RE: 356 State St., BP# 2016-00971 plan review comments - jmb@portlandmaine.gov

Subject: Re: 356 State St., BP# 2016-00971 plan review comments

SHEET TITLE:
FOODSERVICE PLUMBING AND ELECTRICAL ROUGH-IN PLANS

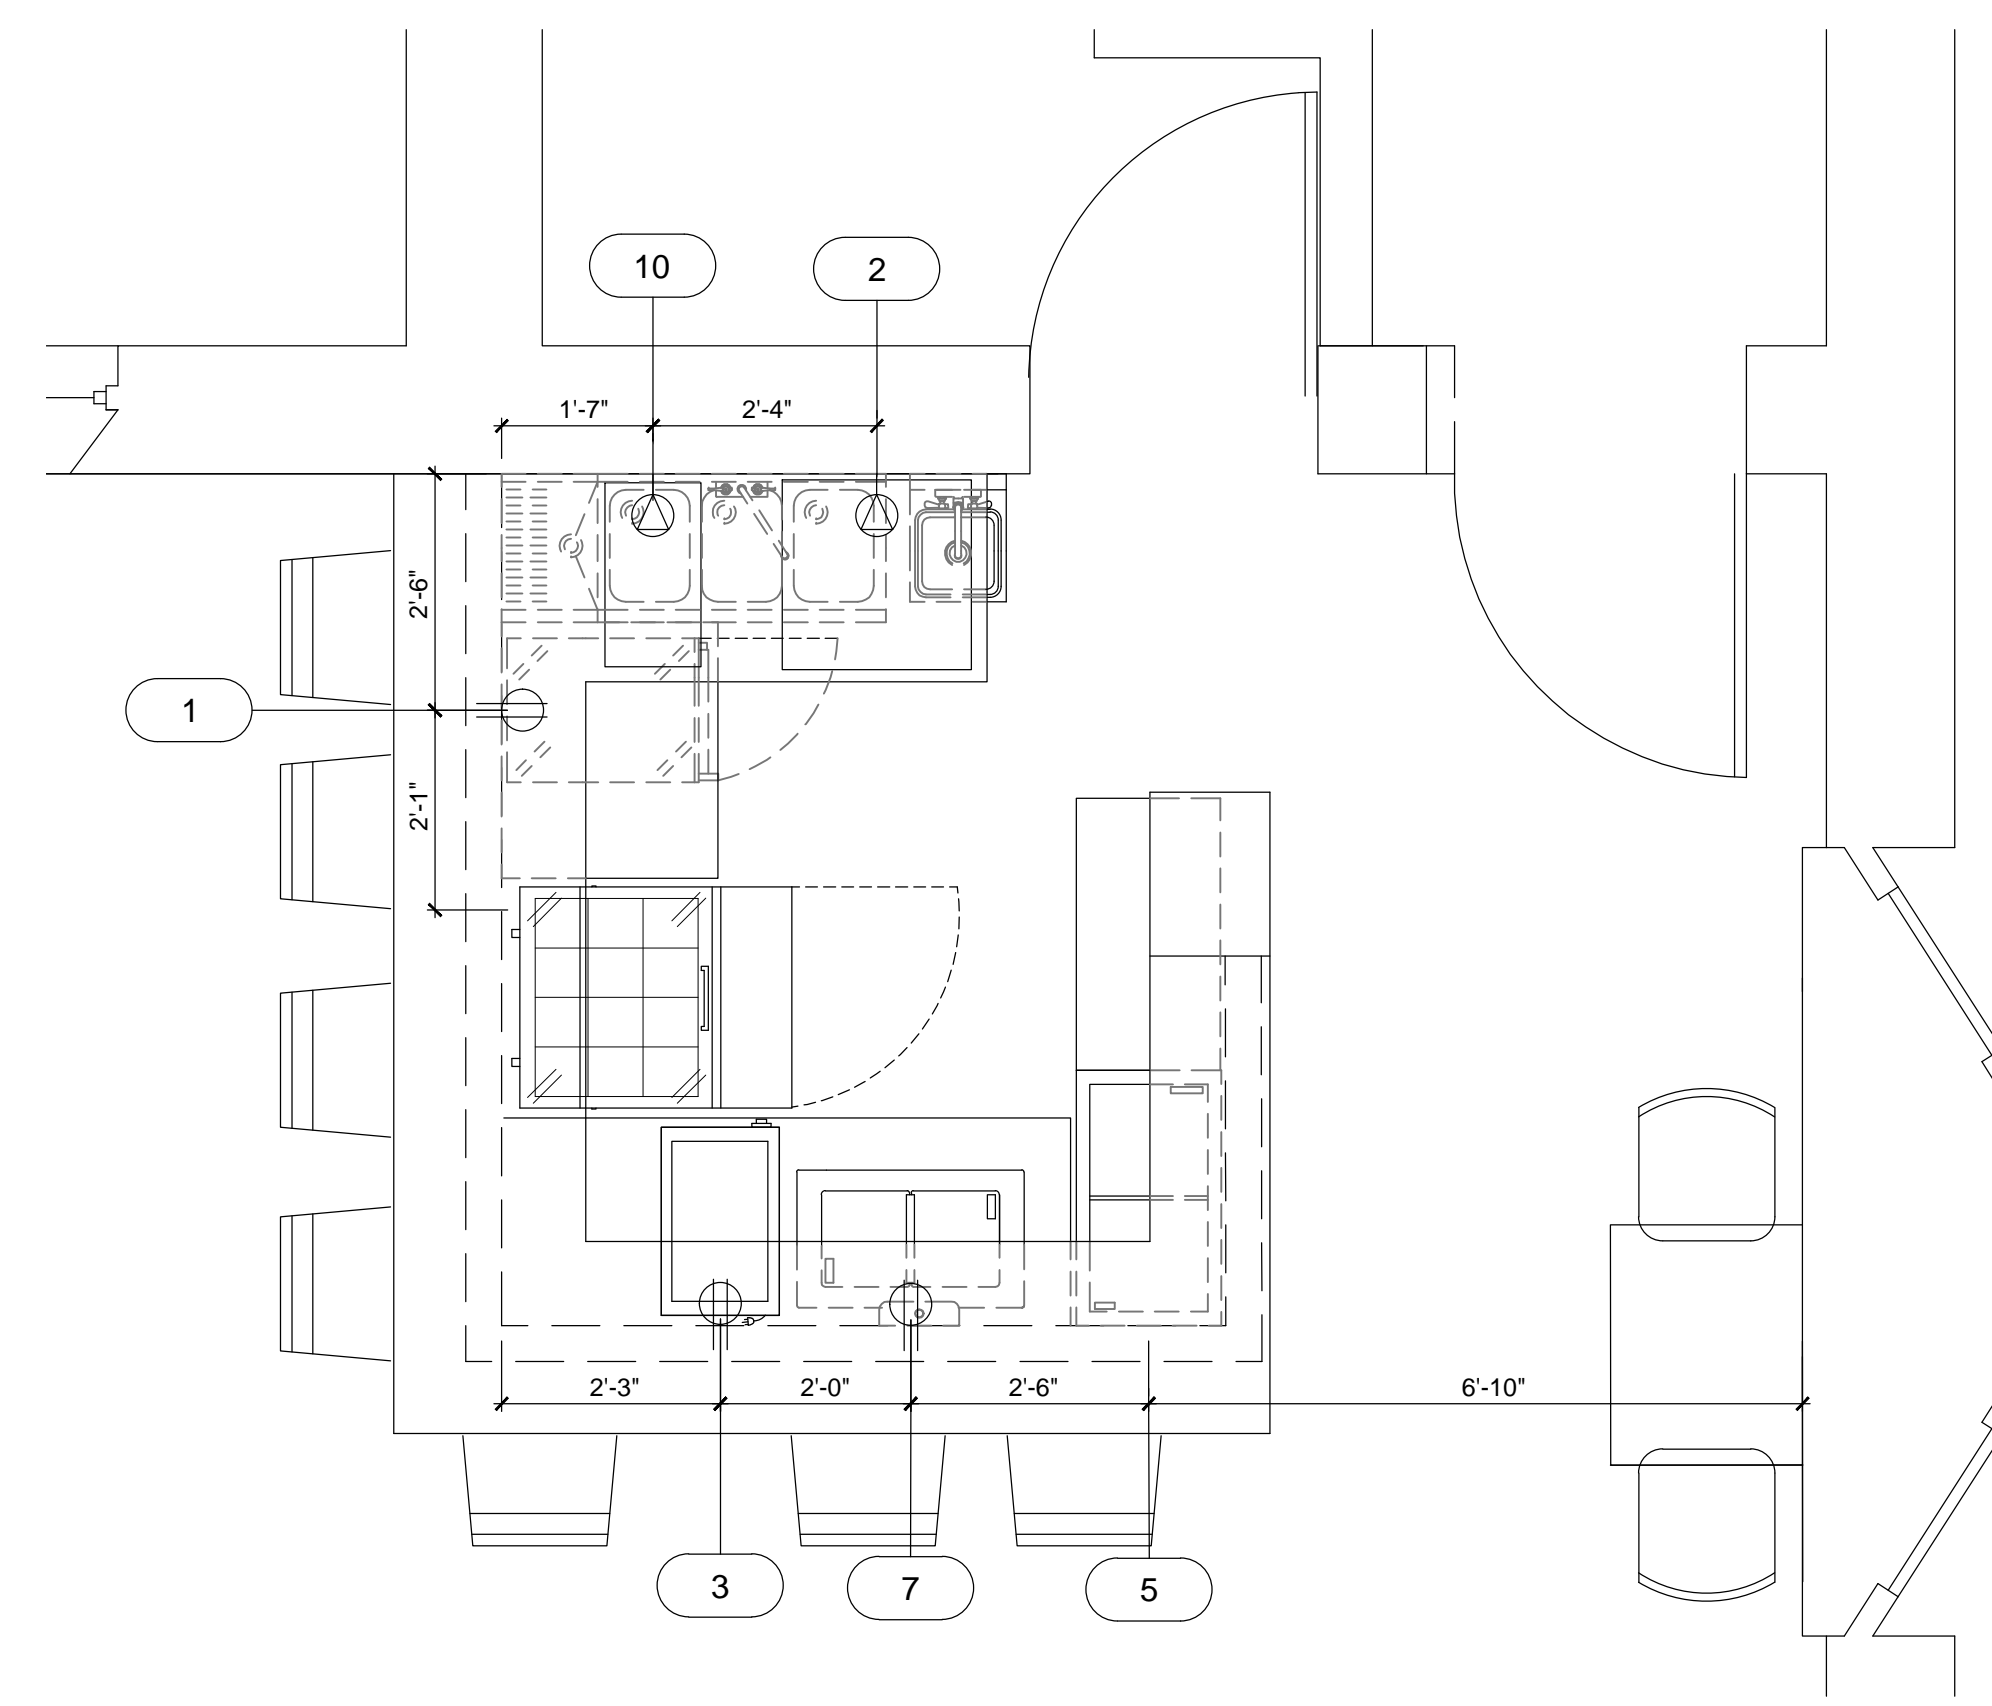
Hi Erin, Thank you for the revised plans dated 5/6/16, this is much more in line with the details discussed with Deen at our preliminary meeting in April. From this, I have one additional comment: 1. The UPC 2009. plumbing code requires wash sinks, including 3 bay and hand wash sinks to be plumbed directly to the drainage system, see Sec. 704.3, and also have a floor drain adjacent to these. The plumbing details shows these fixtures draining to an indirect waste line. Please address this detail. Let me know if you have any questions. Thanks, Jeanie

Hi Jeanie, Please see attached email from Rachel and use these emails to update your records. In short, there will not be a floor drain at the castle. We will be using one of the grease traps recommended by the city and have it maintained consistent with the instructions provided. Please let me know if you have any additional questions. Sincerely, Deen
